6/2021/3422/MAJ - Salisbury Square, Hatfield, AL9 5AD

We are aware that Hertfordshire County Council, as the Lead Local Flood Authority (LLFA), issued a holding objection to the Planning Application for 6/2021/3422/MAJ – Salisbury Square, Hatfield in April 2022. Specifically, the reason provided was;

TITLE: CAR PARKING

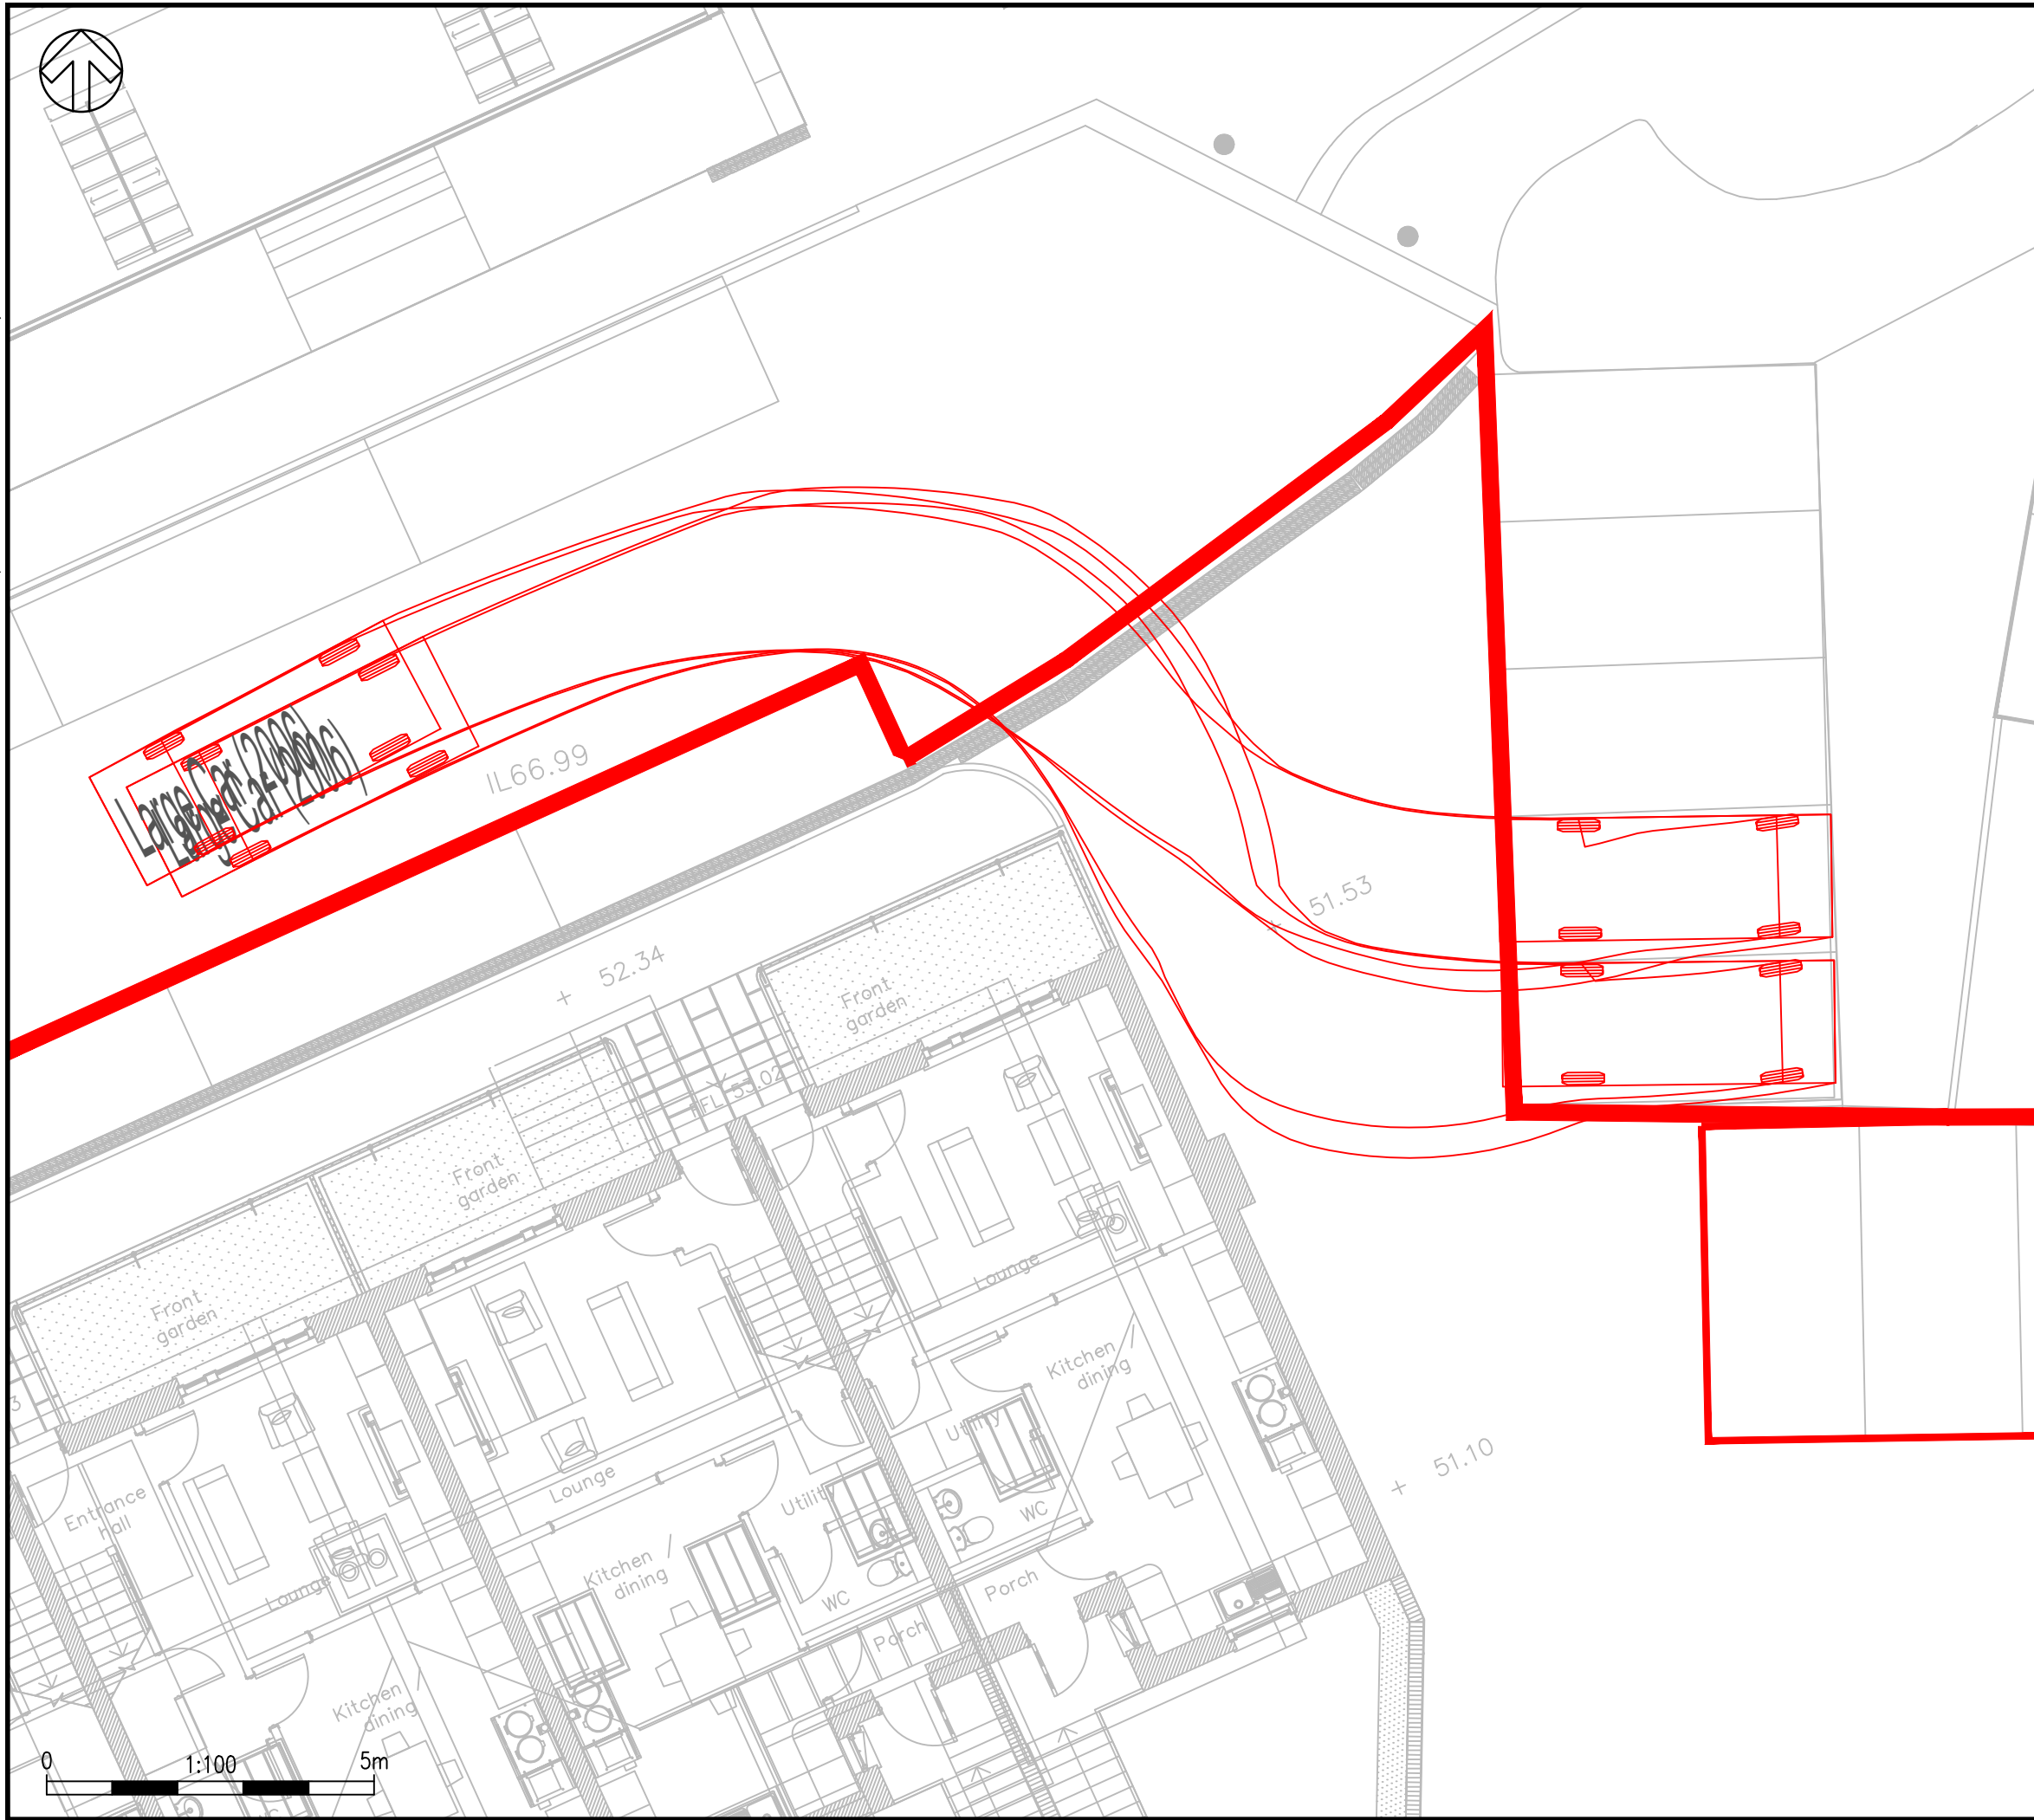
We require further clarification on the current method of discharge from the car park the north of the site which is proposed to drain as per existing arrangement.

No development works are proposed to this area, existing drainage consists of gulleys draining to the adopted sewer network. The location of gulleys has been confirmed through a topographical survey, however connectivity to the sewer this will be confirmed with a CCTV drainage survey at a later stage. This has now been noted in the drainage strategy drawing and within the FRA report.
